CITY OF ALBUQUERQUE

Re: Freddy's

131 Coors Blvd NW

Requested for 60-Day Permanent C. O. - Accepted

GRADING AND
DRAINAGE PLAN

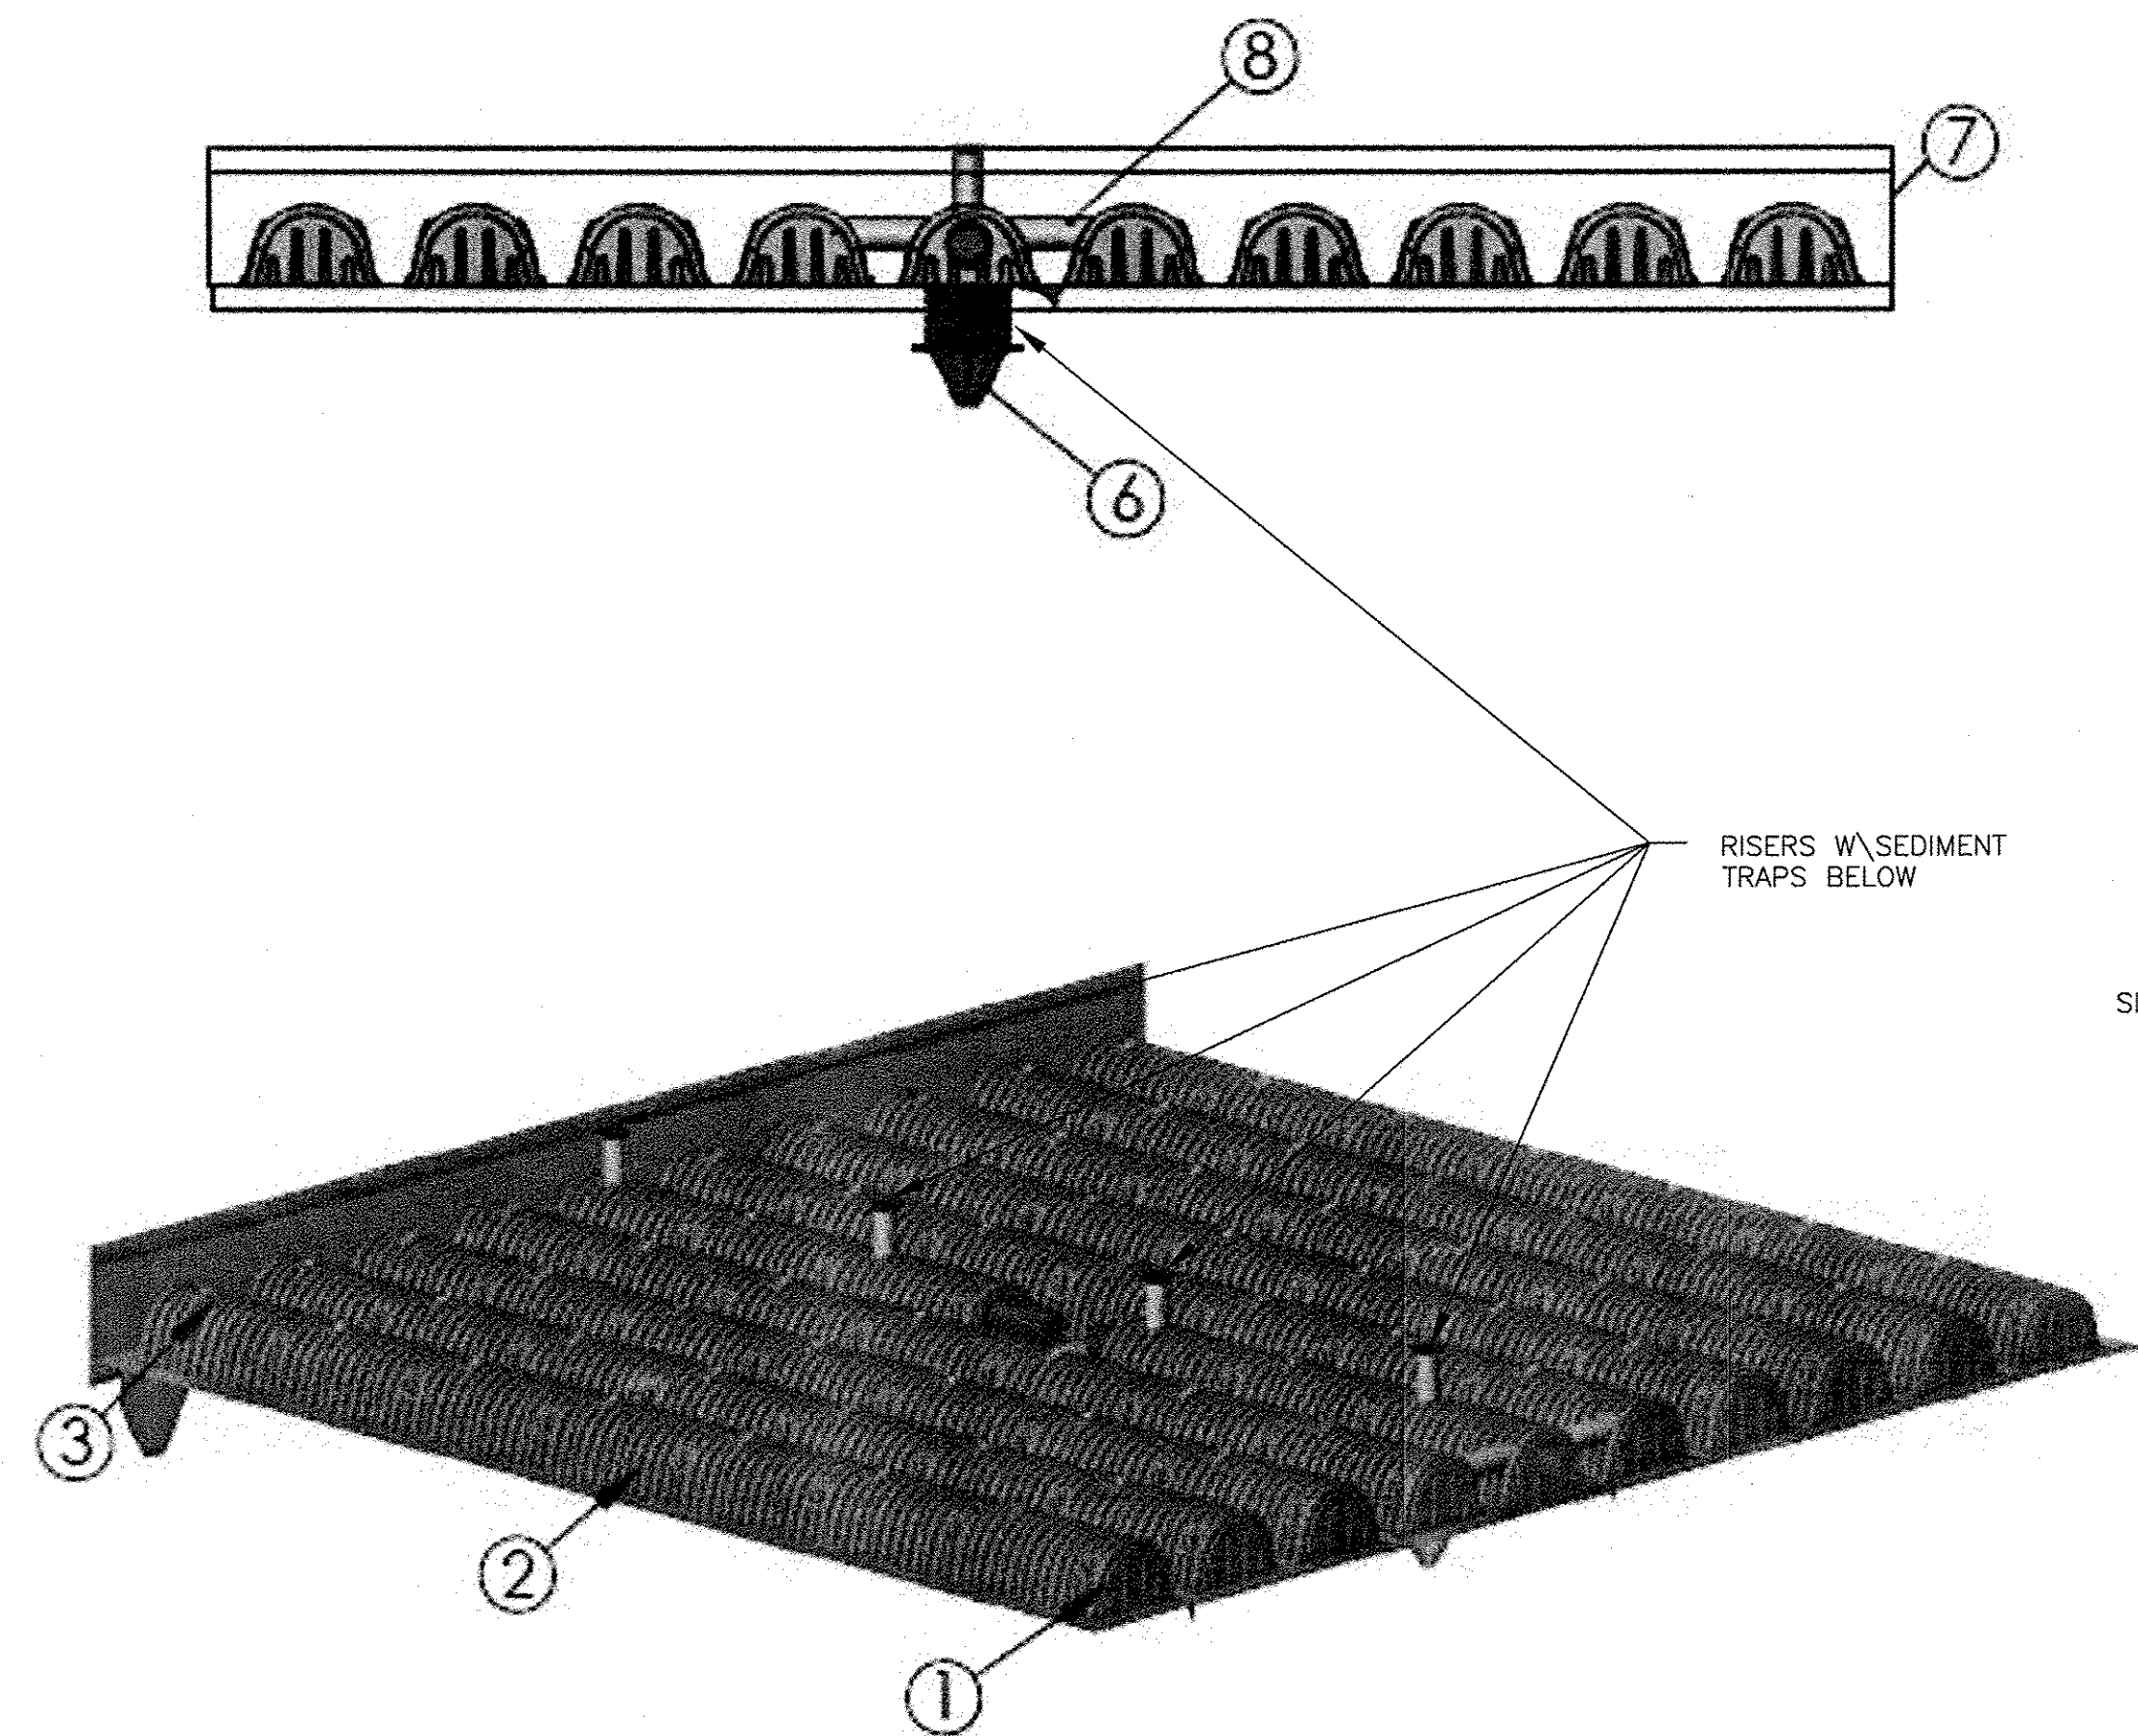
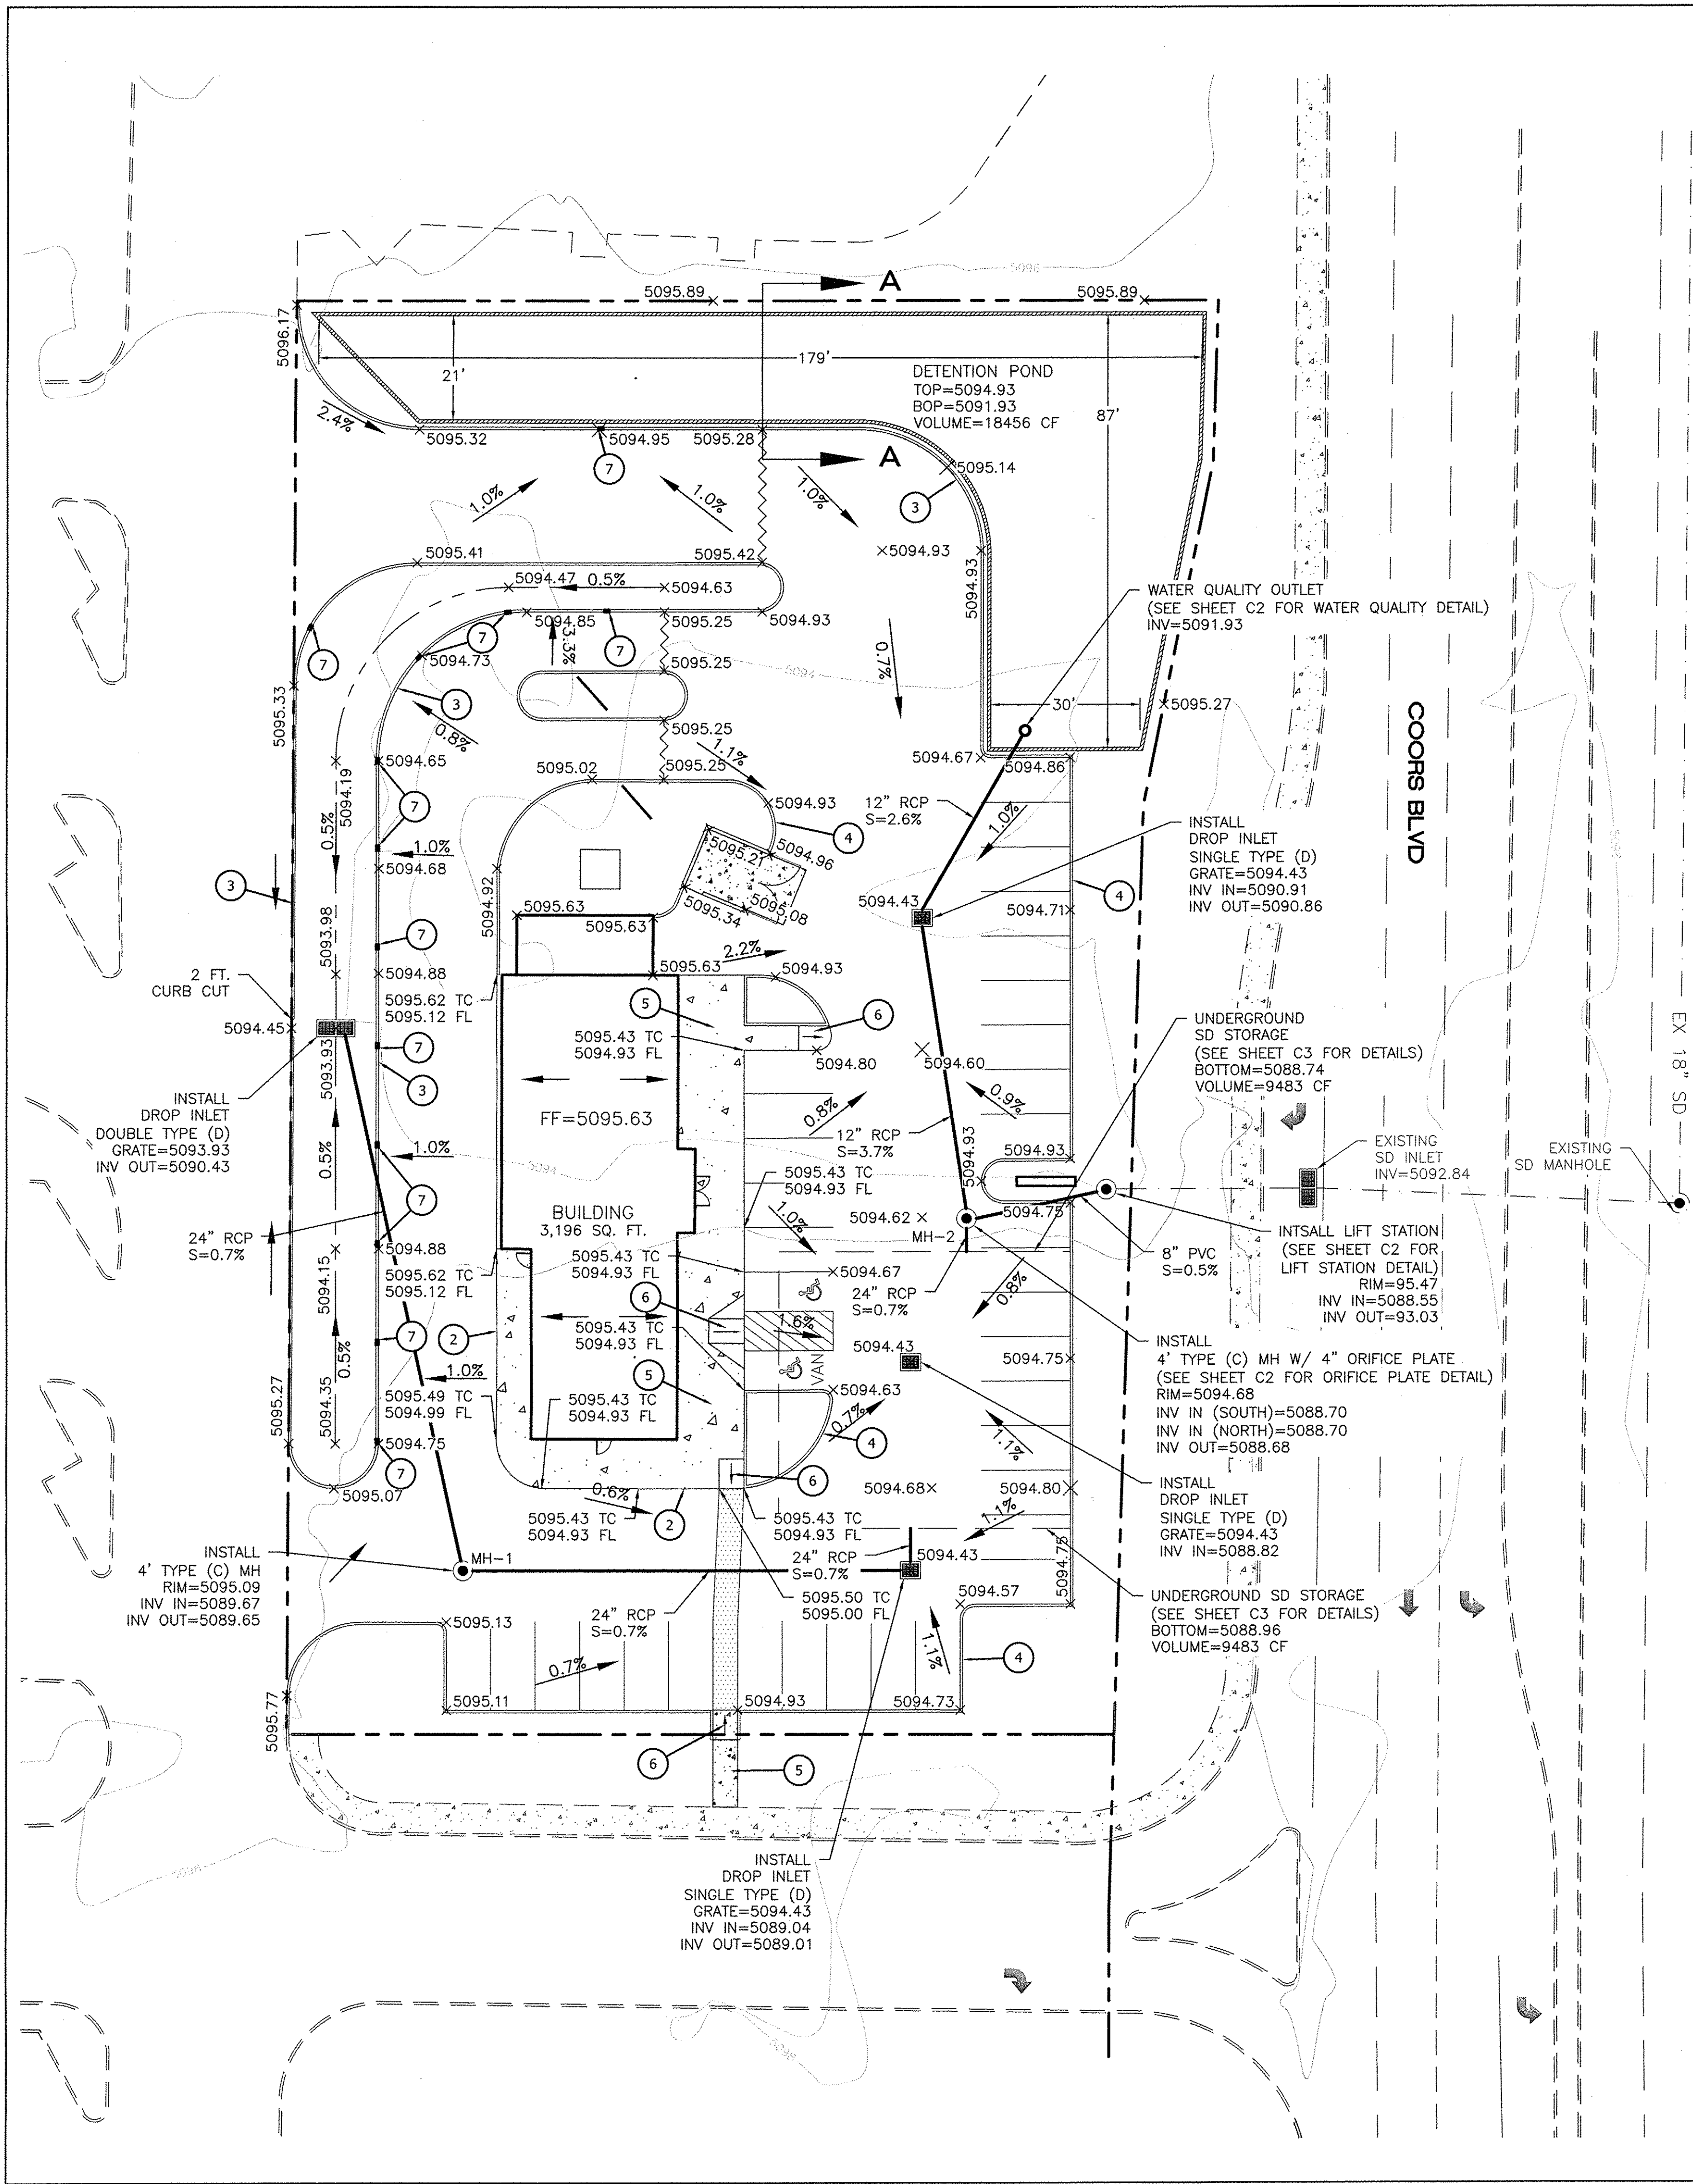
• The Emergency Spillway appears to flow back into the pond. Per the drawings the flow was towards the NE corner of the spillway. Should the ponds every completely fill up the water may back flow into the site.
